Alex Hampson  
Scottish Power Renewables  
320 St Vincent Street  
Glasgow  
G2 5AD

Tues 19 December 2017

## **Gallopier Response to East Anglia 1North and East Anglia Two Scoping Reports**

Drawing file: published-documents / EN010077-001079-6.2.7.7 EA1N ES Figure 7.7 Offshore Cable Corridor and Landfall.pdf

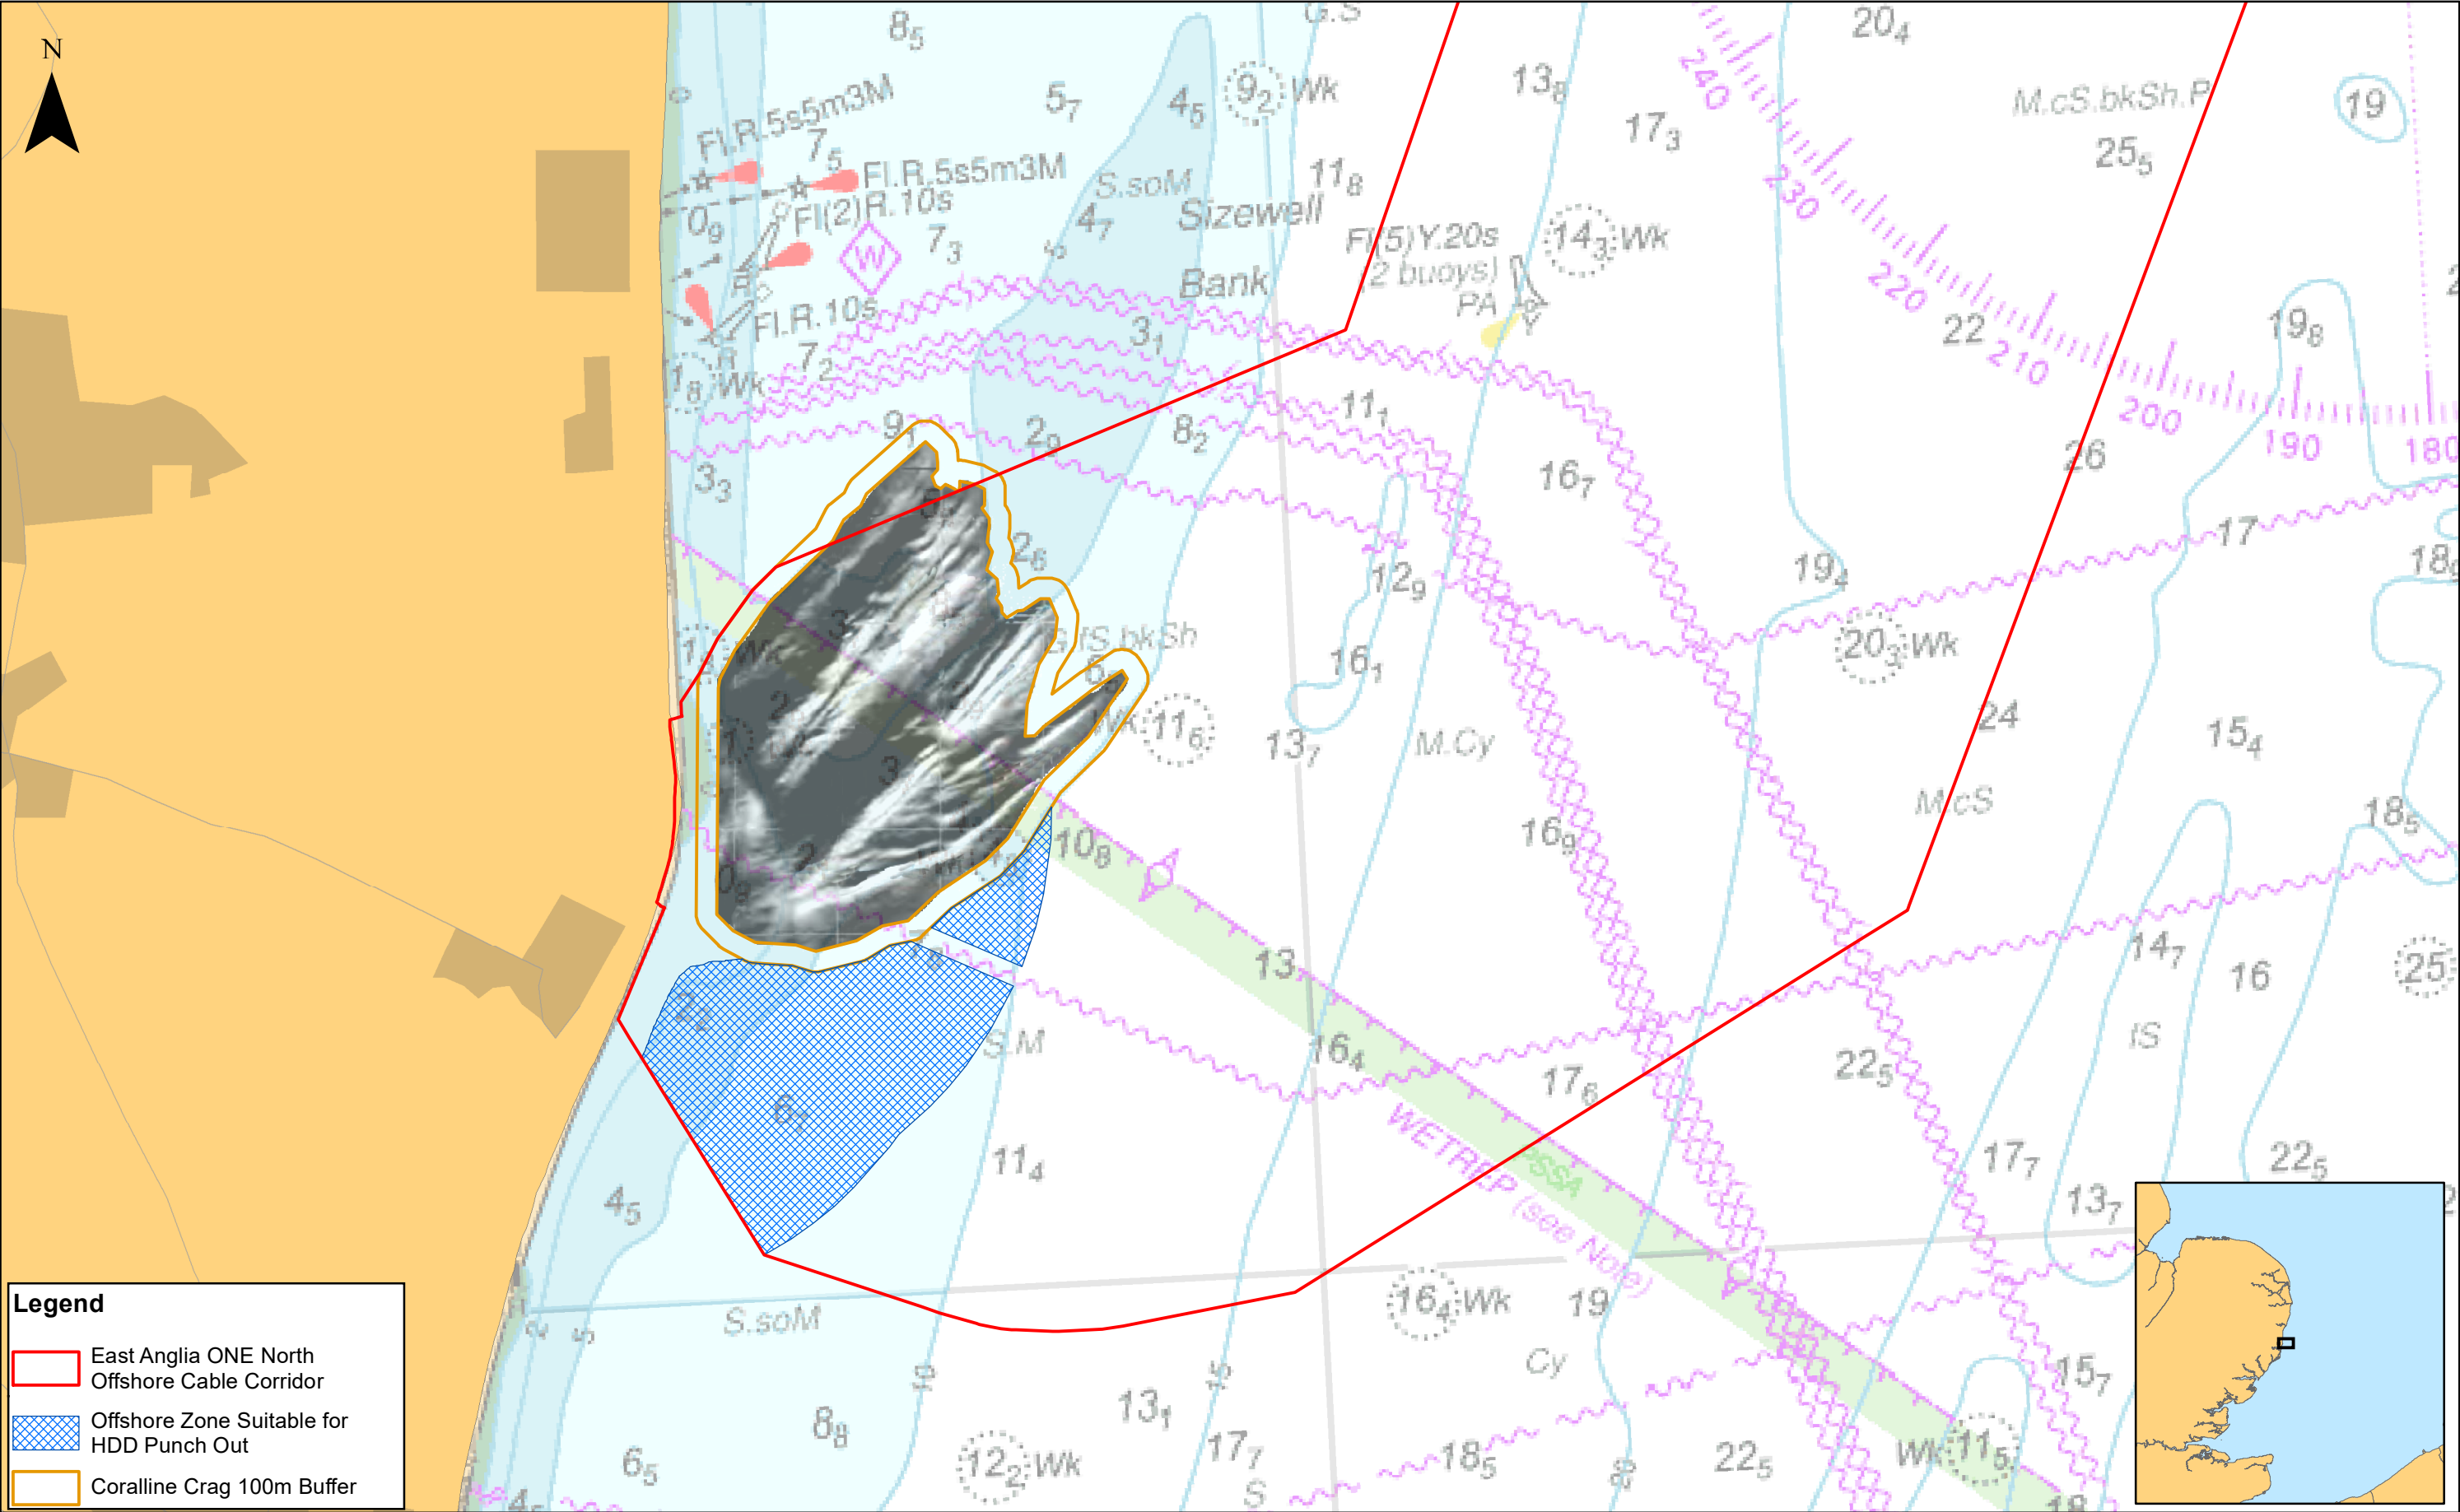
- 7) There is one AoS for a shared offshore export cable route for East Anglia One North and East Anglia Two. The figure shows the East Anglia cables will cross the Galloper cables within 10km of the shore. GWFL expects a formal cable crossing agreement between GWFL and applicable projects to be in place in advance of the DCO application being submitted. GWFL would welcome early consultation including the review of method statements in relation to this.
